From: Bob Neville  
Sent: 26 May 2020 10:32  
To: DC Support  
Subject: FW: 20/00841/F - Barn And Land South West Of Cotefield Farm Church Street Bodicote

<b>Planning application:</b>	20/00841/F
<b>Location:</b>	Barn And Land South West Of Cotefield Farm Church Street Bodicote
<b>Description:</b>	Erection of garage adjacent to approved dwelling and change of use of agricultural land to residential use
<b>Type:</b>	Full Development
<b>Case Officer:</b>	Bob Neville

DRAWING NUMBER:
4728/21H

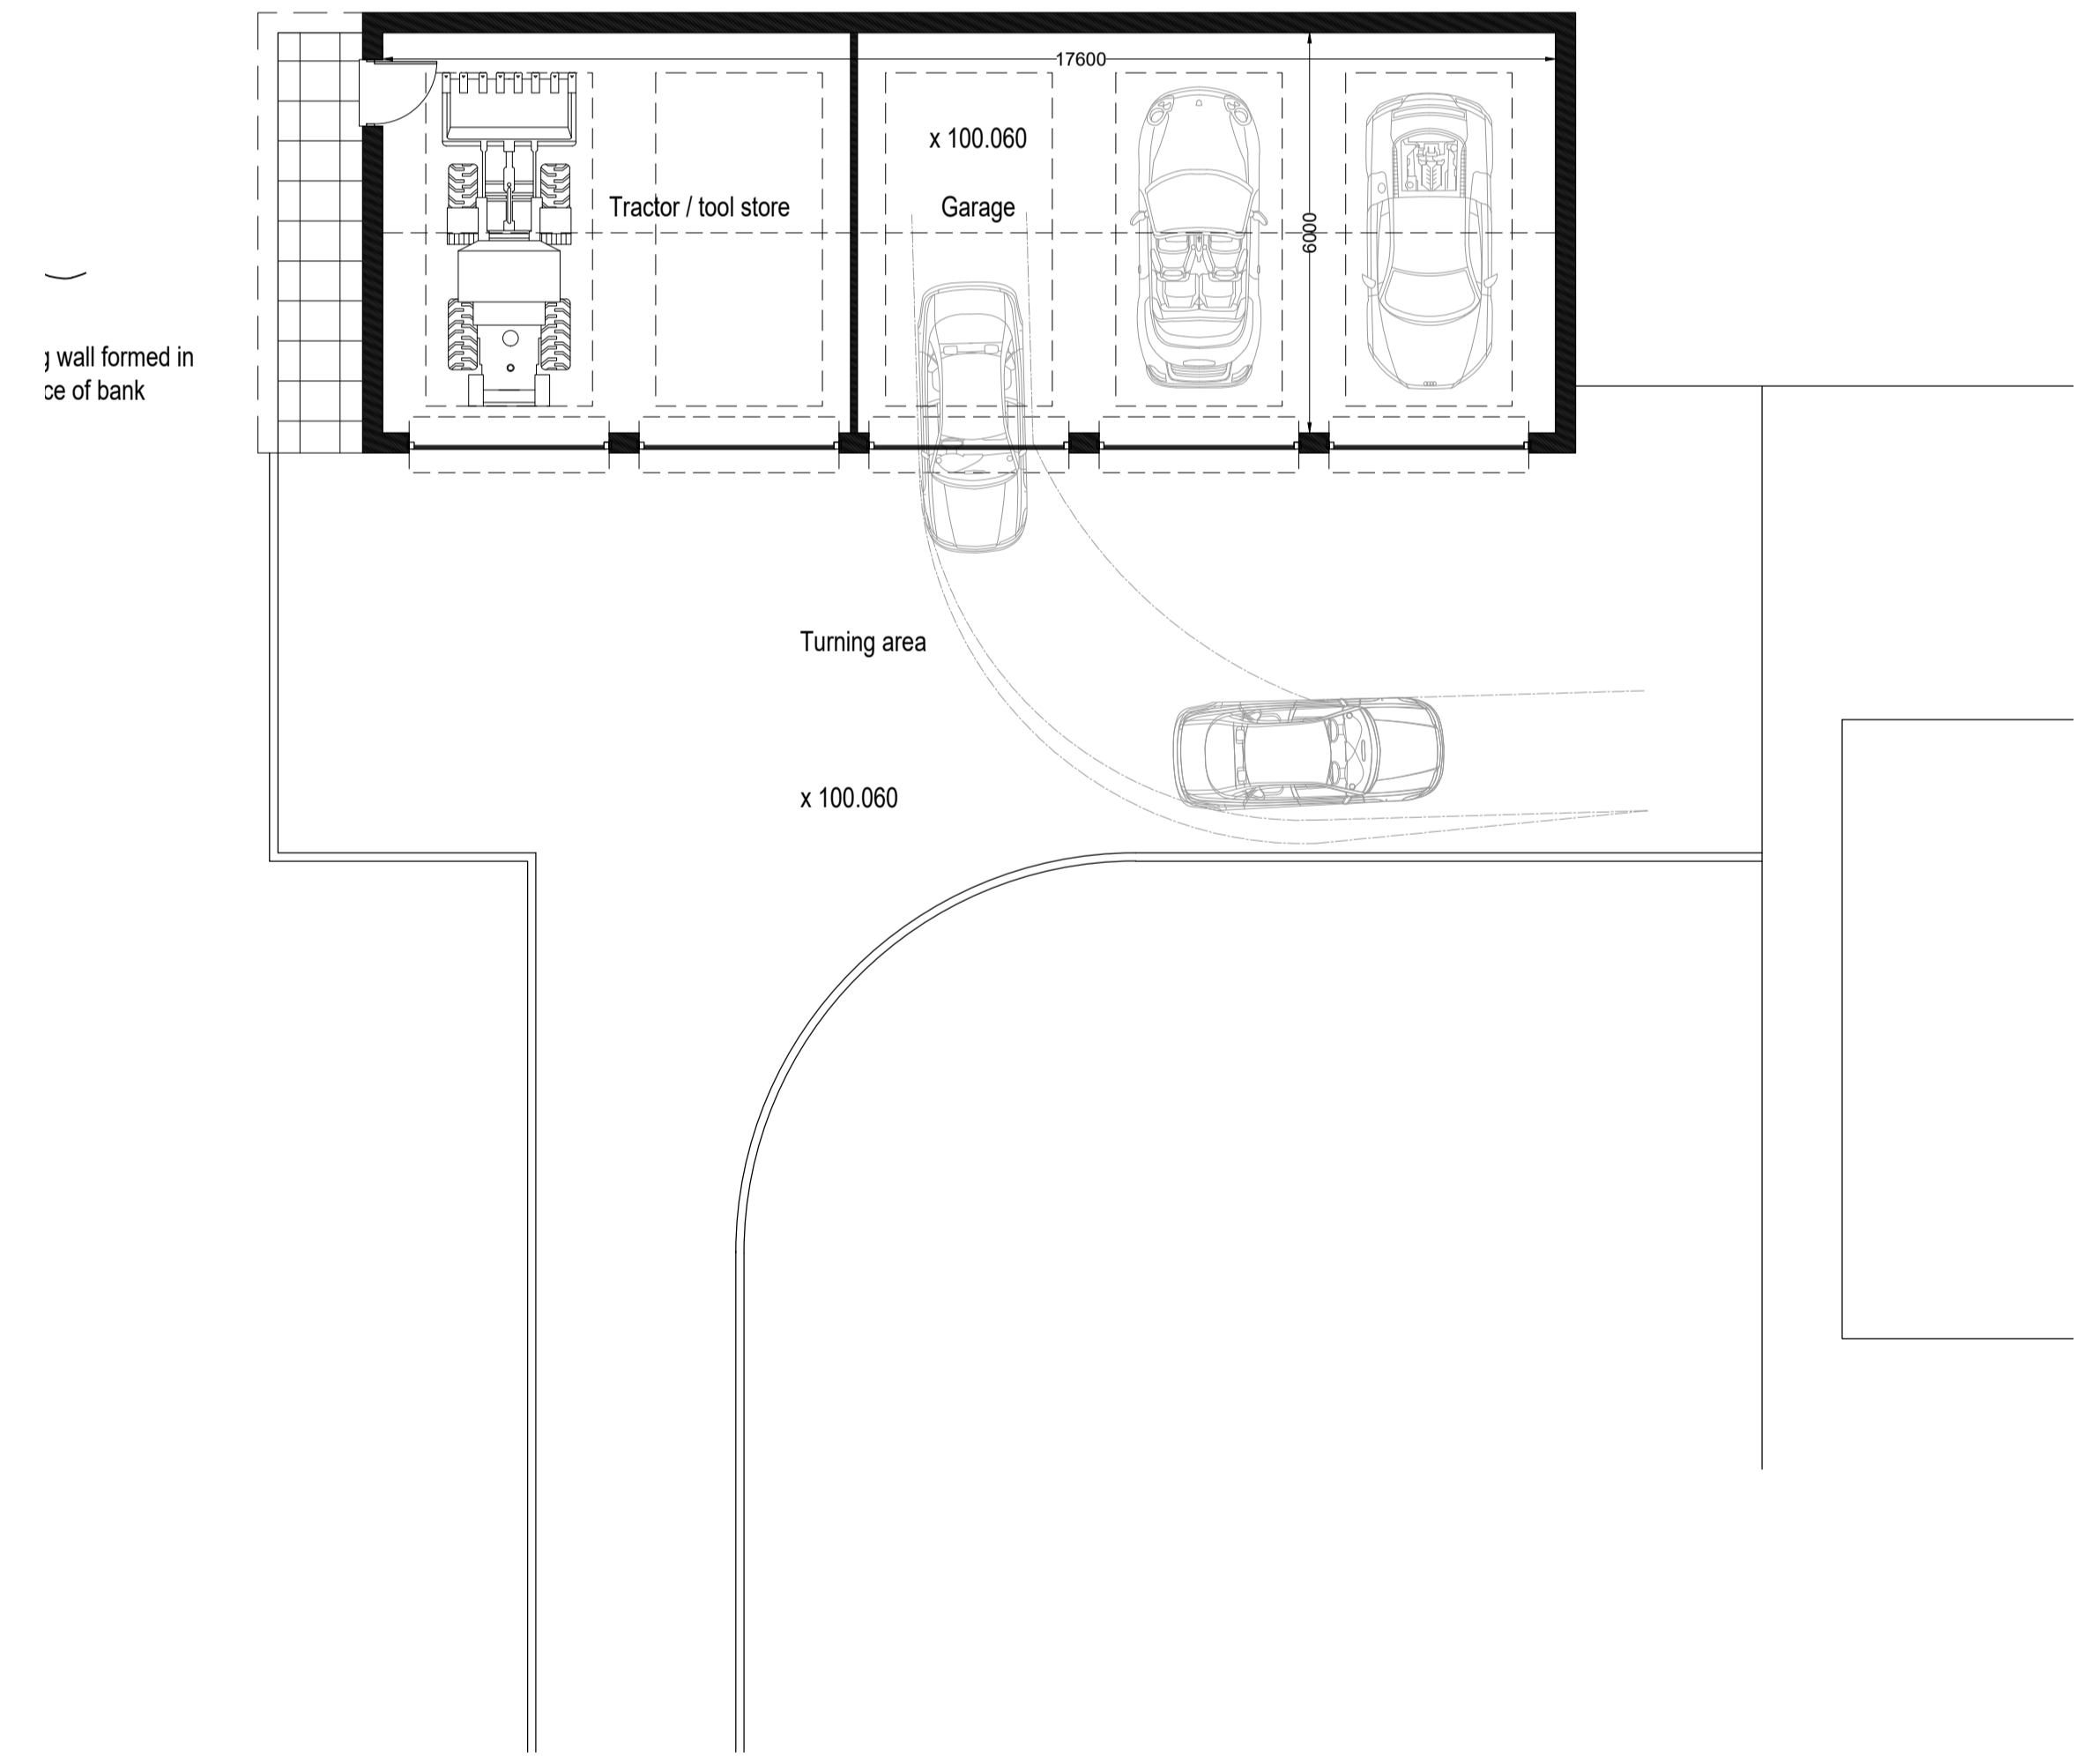
Prior to the first use/occupation of the development hereby approved, the parking and manoeuvring areas shall be provided in accordance with the plan approved (Drawing No. 4728/21H) and shall be constructed from porous materials or provision shall be made to direct run-off water from the hard surface to a permeable or porous area or surface within the curtilage of the site. Thereafter, the parking and manoeuvring areas shall be retained in accordance with this condition and shall be unobstructed except for the parking and manoeuvring of vehicles at all times. Reason - In the interests of highway safety and flood prevention and to comply with Policies ESD7 and ESD15 of the Cherwell Local Plan 2011-2031 Part 1 and Government guidance contained within the National Planning Policy Framework.

The proposals are unlikely to have any adverse impact upon the local highway network from a traffic and safety point of view, therefore I offer no objection, subject to a conditions. First to restrict the use of the garage for the purpose only as a garage and a further condition ensuring. And second the parking and manoeuvring areas and shall be constructed from porous materials or provision shall be made to direct run-off water from the hard surface to a permeable or porous area or surface within the curtilage of the site.
